From: Amber Willard
Sent: 28 August 2026 12:10
To: [REDACTED]
Cc: Paul Cann
Subject: RE: Stoney Brook Farm, Walberton - Land Drainage Byelaw Consent

Ditch Long Section
Scale H 1:250
V 1:50

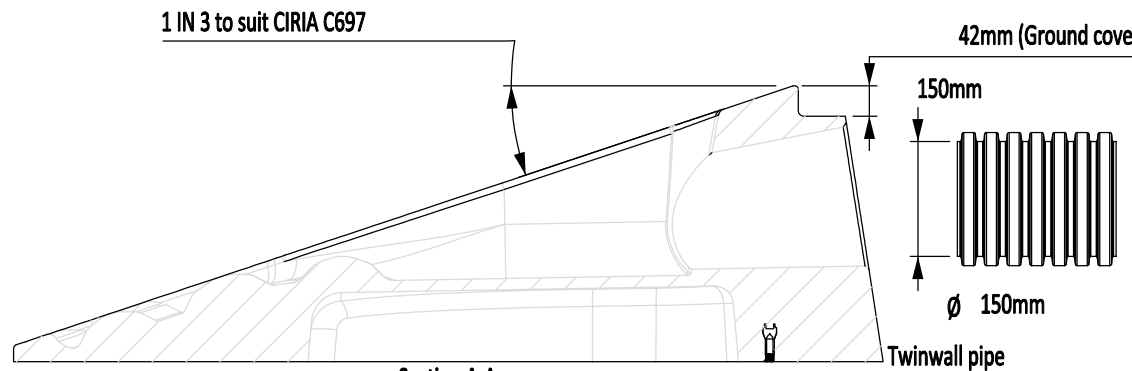
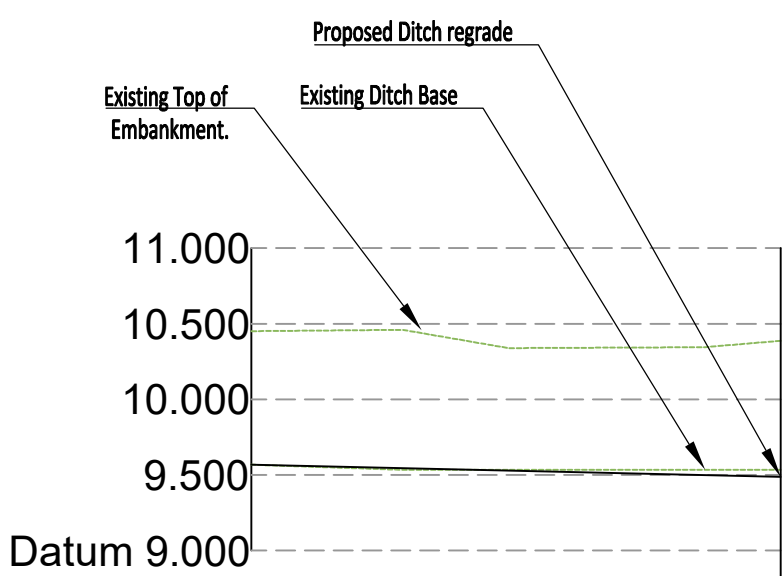
1. At least 150mm freeboard needs to be achieved between the outfall pipe invert and ditch bed. This will require regrading of the ditch. Please provide full details of how this will be achieved. A longitudinal section over a suitable length will be required to verify what is possible and ensure that the ditch maintains a positive gradient. This will need to be supported by appropriate cross sections to ensure that there is no detrimental impact to the banks (slopes) as a result of the regrading.

1. The ditch will be regraded to create a 1:250 fall past the outfall. **ok**
2. The headwall detail has been added. **Ok but notes associated with the headwall detail appear to be missing.**
3. Payment has been made. **Please provide evidence of payment.**

Elevation of Headwall Outfall
Scale 1:20

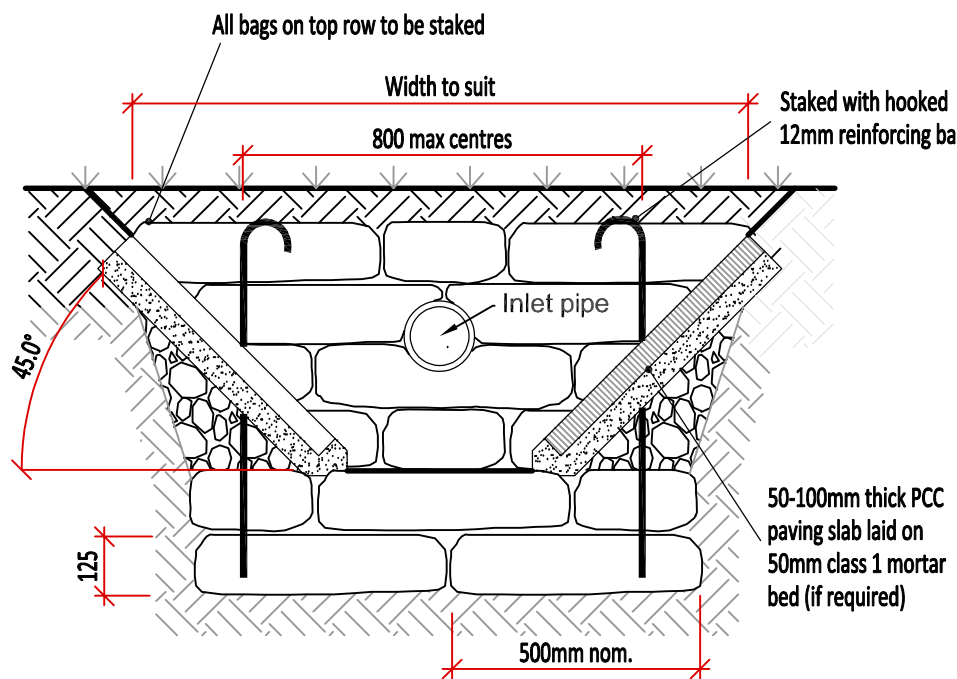
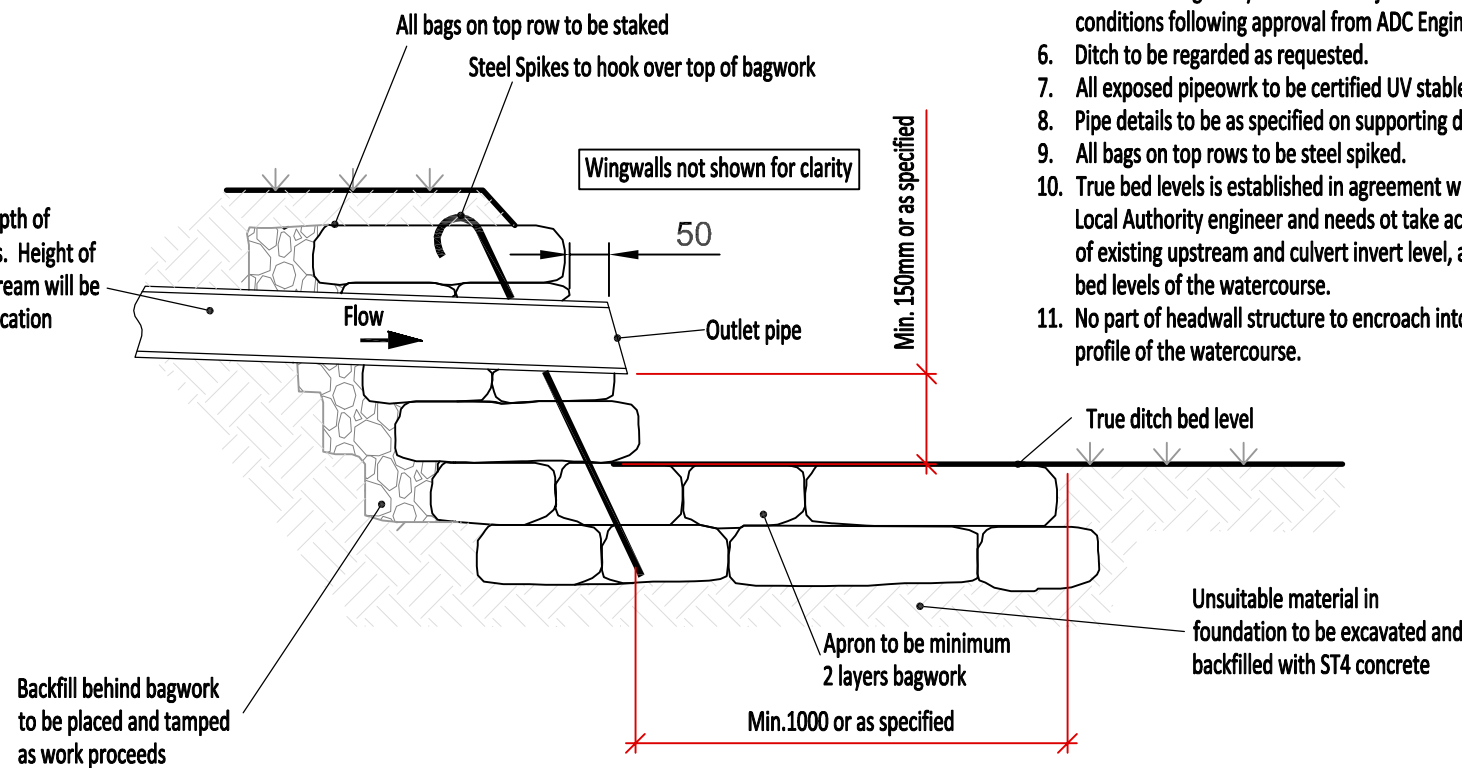
2. No headwall construction details have been provided (Only for the basin). I have enclosed our standard headwall details to assist – the 'side of ditch' detail can be utilised if desired, together with the notes in the right hand side of the drawing. The apron and paving slab erosion control can be omitted in this instance. Or you may wish to alter your basin headwall detail to comply with all the requirements shown on our drawing?
